GG/06/6475(25 June 26)NMA

**PLANNING APPLICATION REF: 2022/62/91477/W
NON-MATERIAL AMENDMENT REGARDING APPROVED ELEVATIONS FOR UNIT 5 (Unit P
AS APPROVED)**

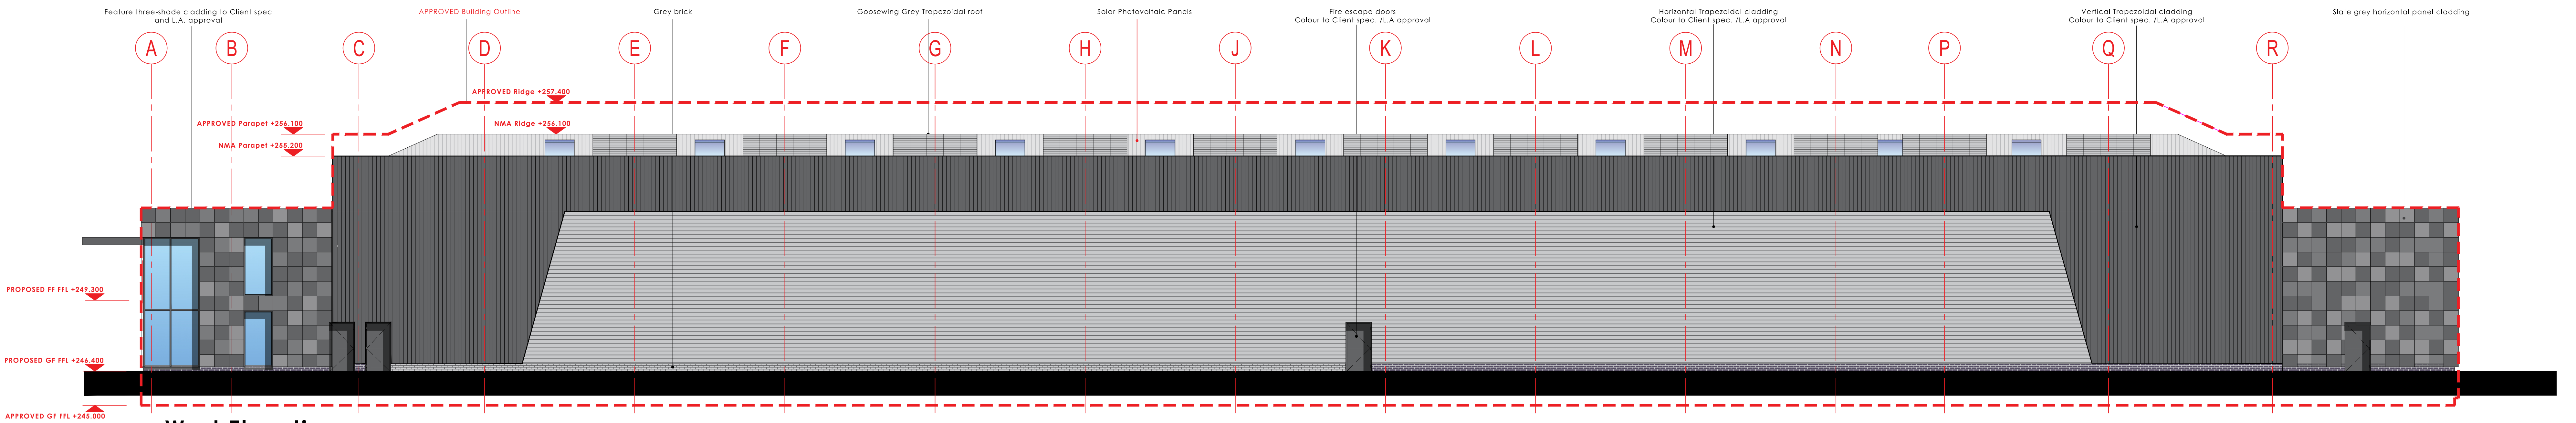
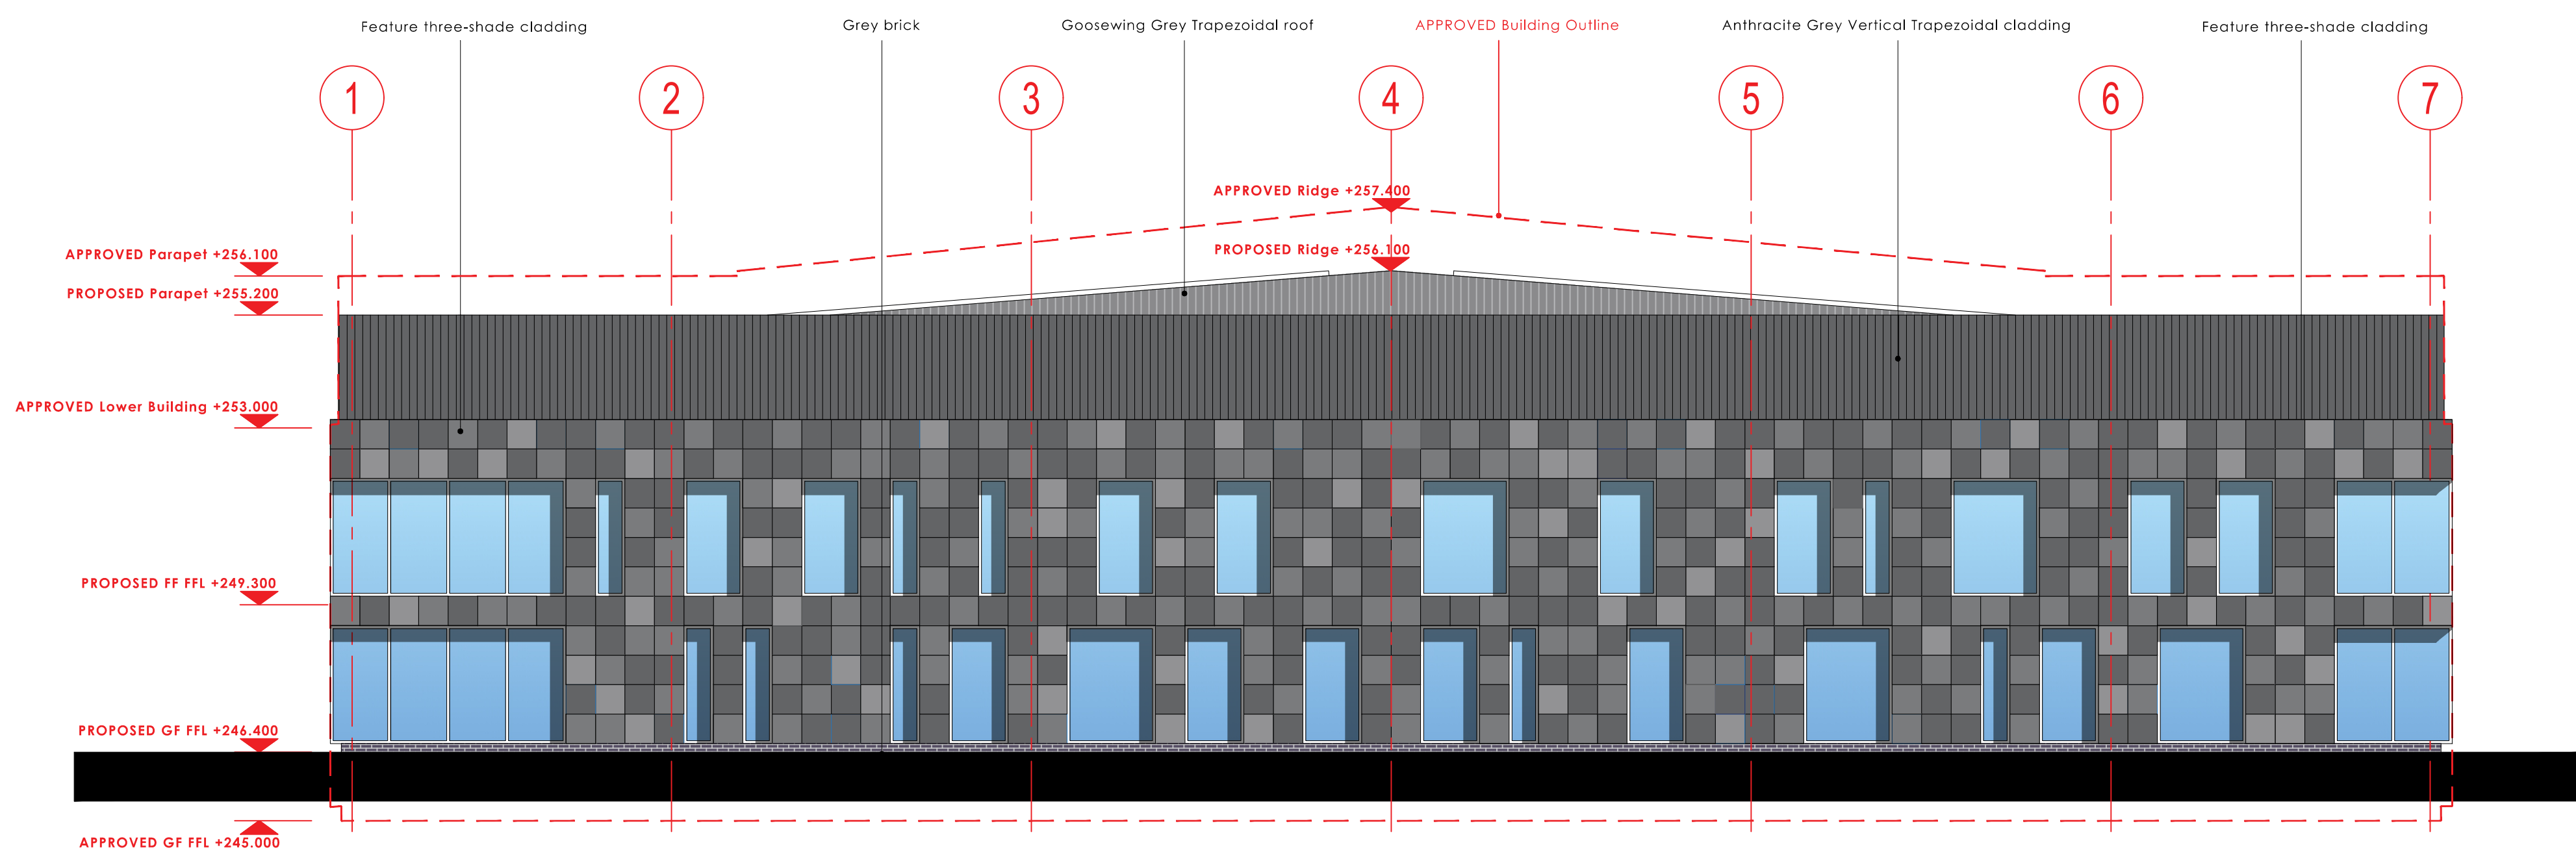
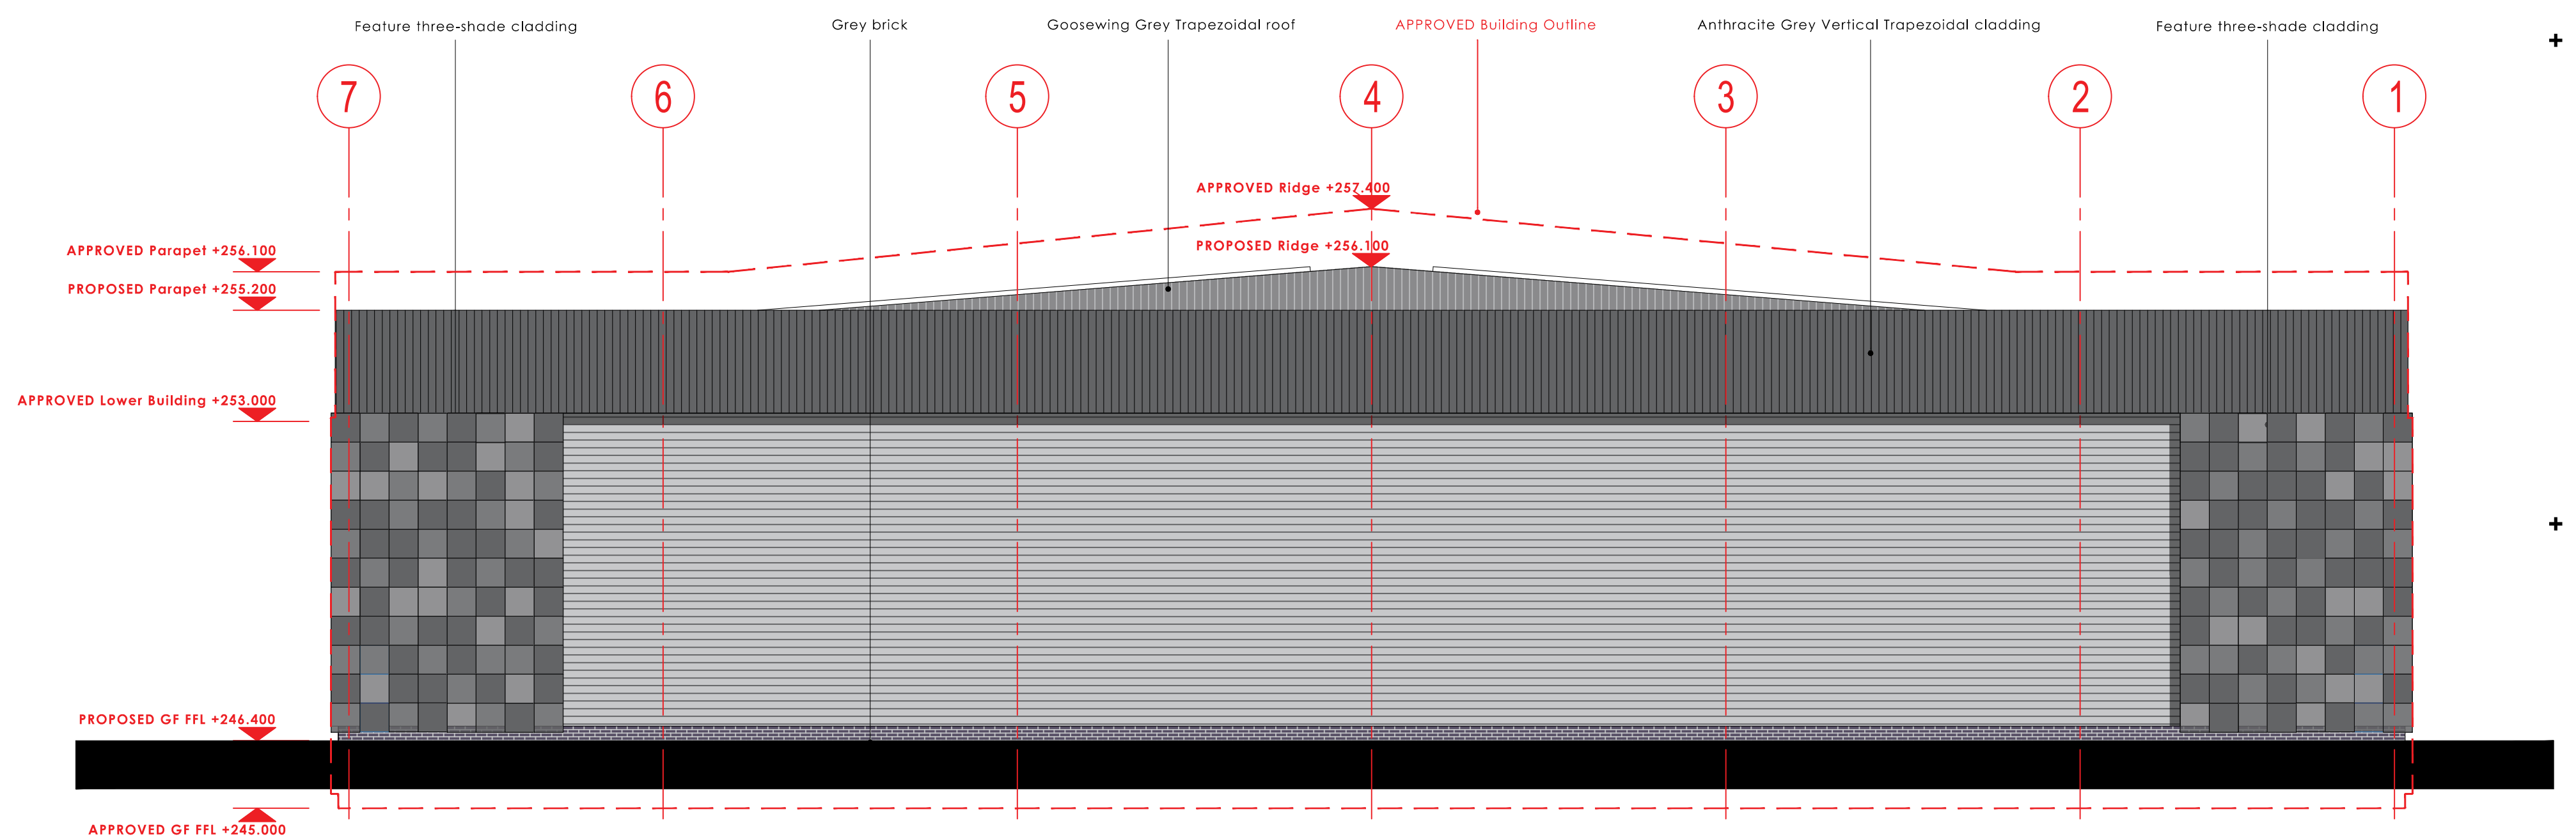
As shown on the proposed plan, the amendments would result in the ridge height reducing by circa 1.3m with the parapet reducing in height by circa 900mm. Notwithstanding these amendments, there are no material changes to the external appearance of the proposed unit and it is considered that these amendments can be treated in a favourable manner by way of a NMA application
